Application for Planning Permission for Works or Extension to a Dwelling

Development: Proposed single storey front extension.
Location: 5 Church Lane Pagham PO21 4NS

PART GROUND FLOOR
PLAN. [AS EXISTING]
1:50 @ A3.

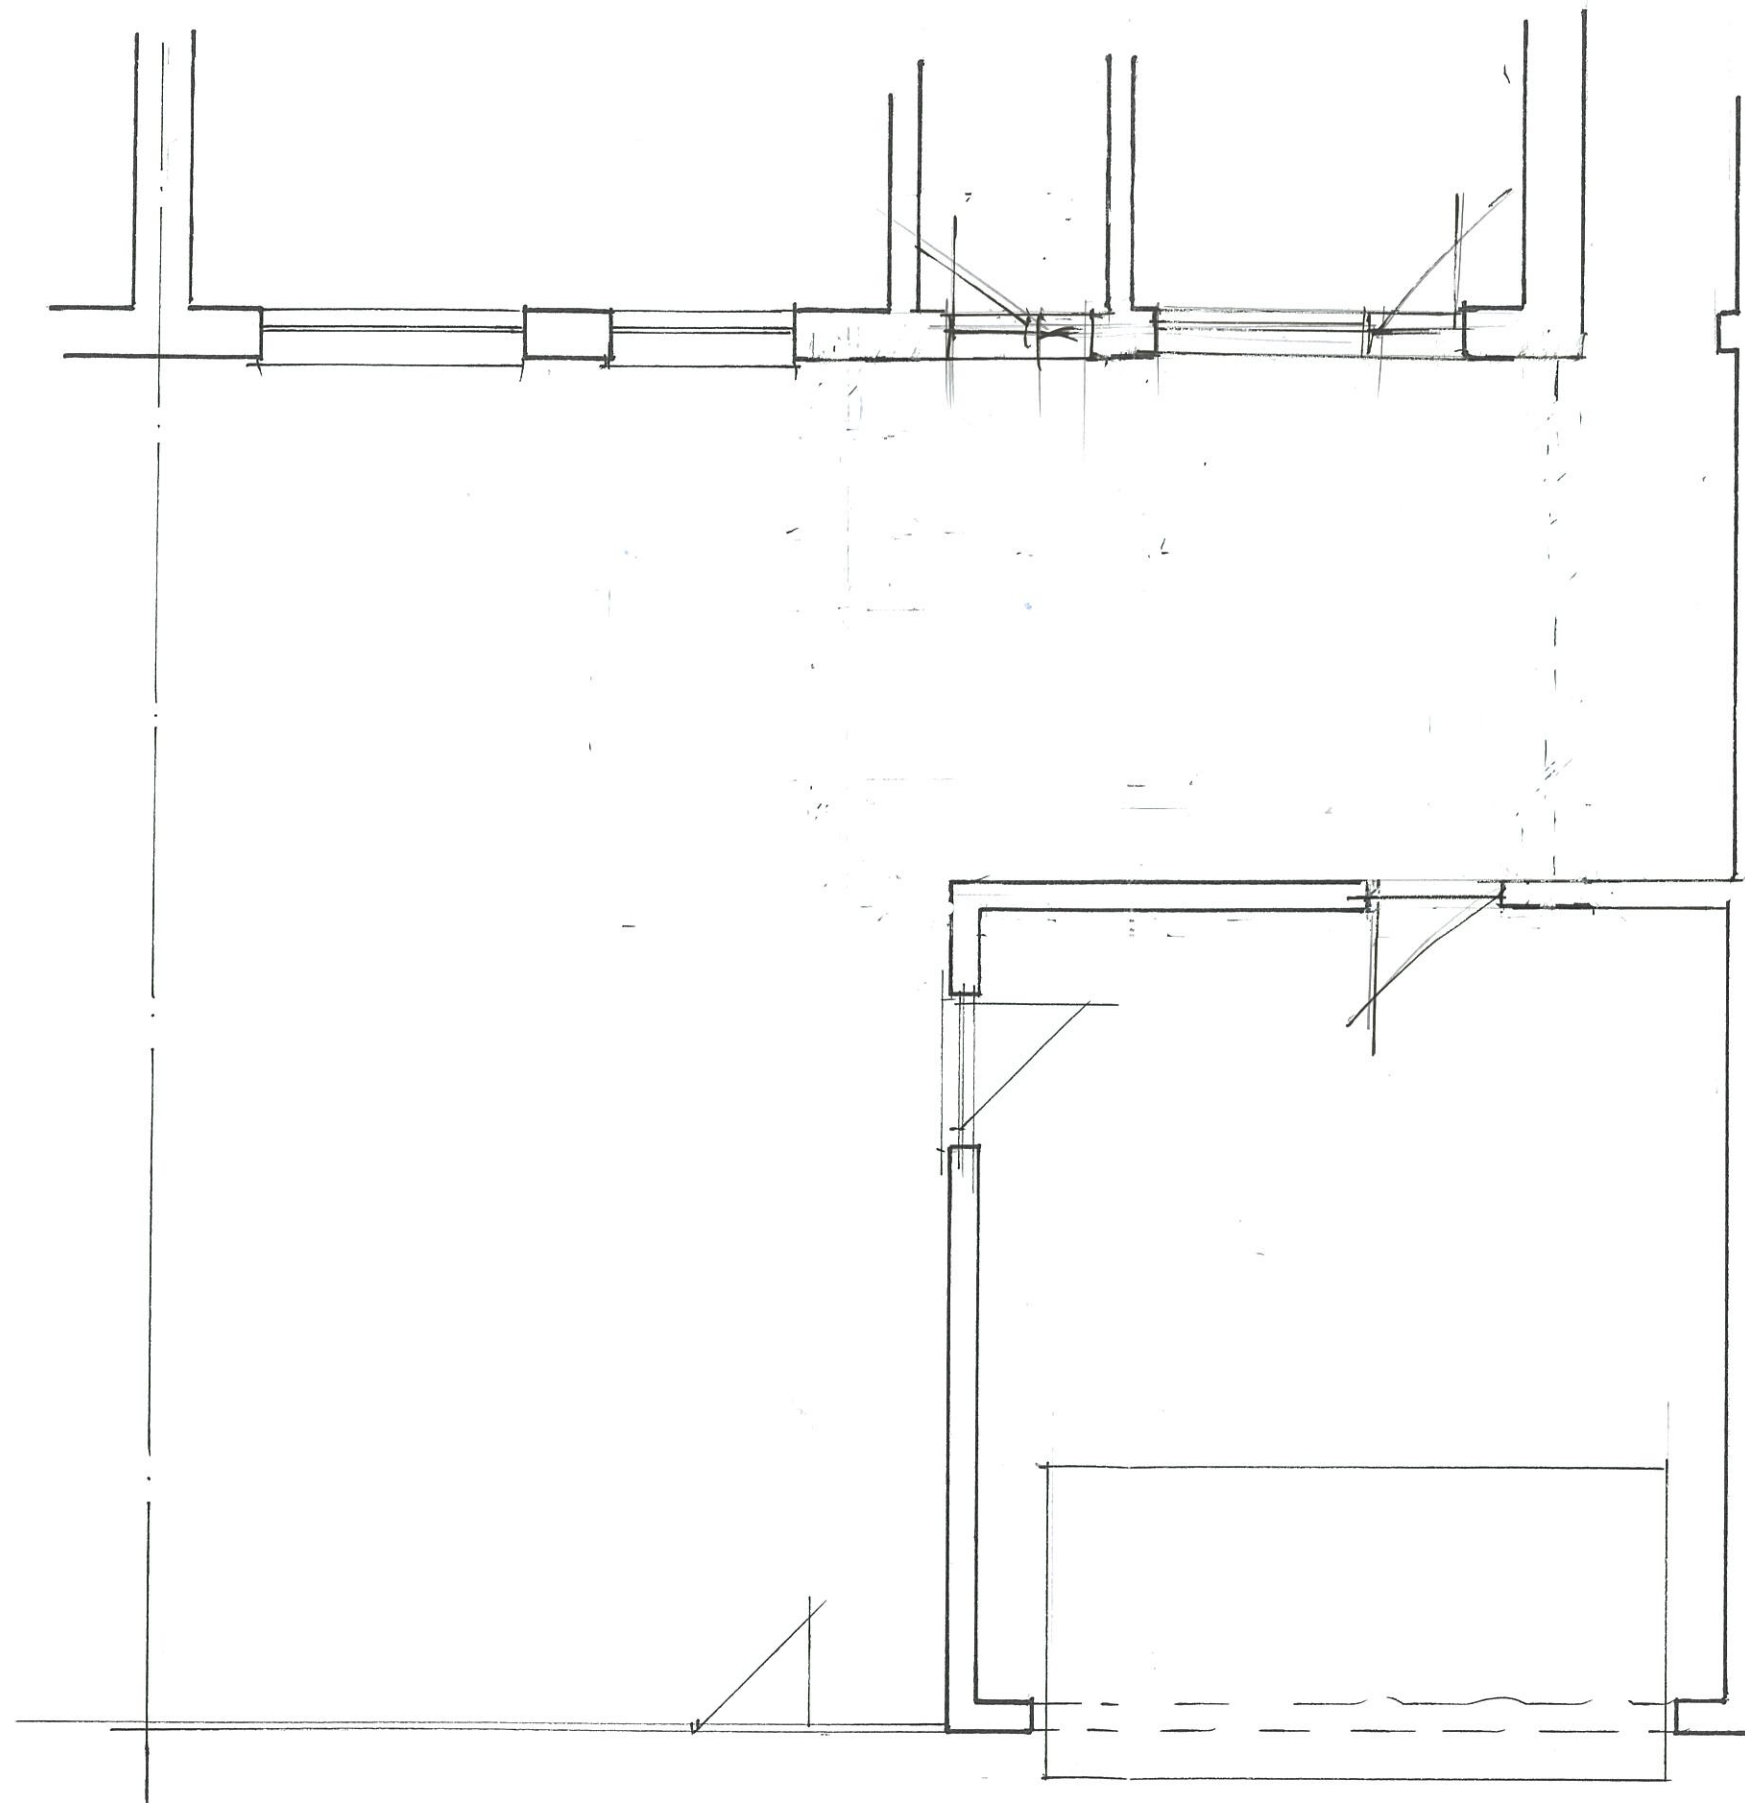
The existing floor plan has been labelled as proposed, please review and amend.
